**SUBJECT: BRES2405-0069
BUILDING RESIDENTIAL**

Here are the results of all Inspections located at **524 LONGLEAF DR:**

FOOTING PLAN	
FOOTING DETAILS	
524 LONGLEAF DRIVE—LILLINGTON, NC	Scale: NTS
Date: 9/9/2024	Revisions:
Donald D. Paschall, Jr., P.E. (PE License # 22543) 318 S. Spruce Street — PO Box 291 Proctorville, NC 28375 (910) 734-2005 donaldpaschall@gmail.com	
2 OF 2

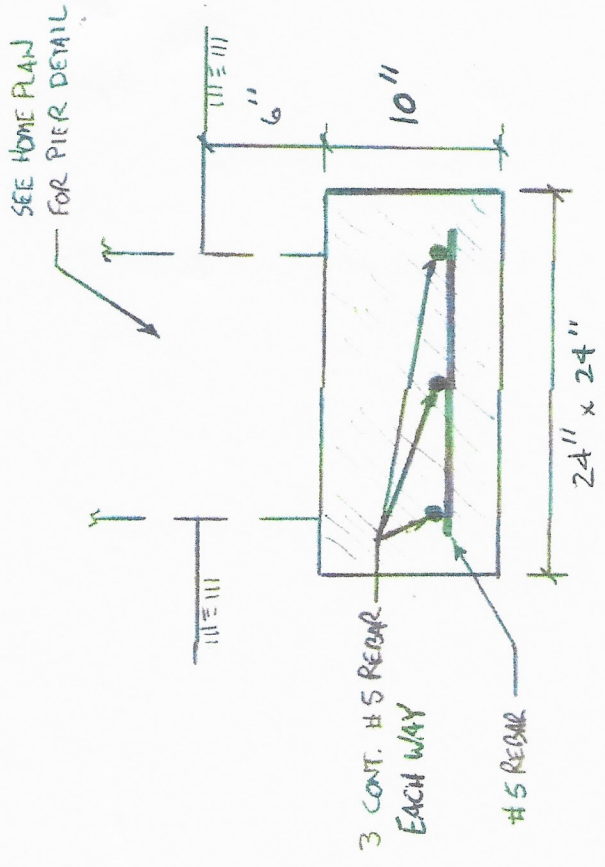
No plans in permit box
Need to clean loose dirt from bottom of footings
Need to mark depth of footings
Missing step downs in footings

Footing has water in them. Need to clean out and has crush and run in the footing. Need engineer letter
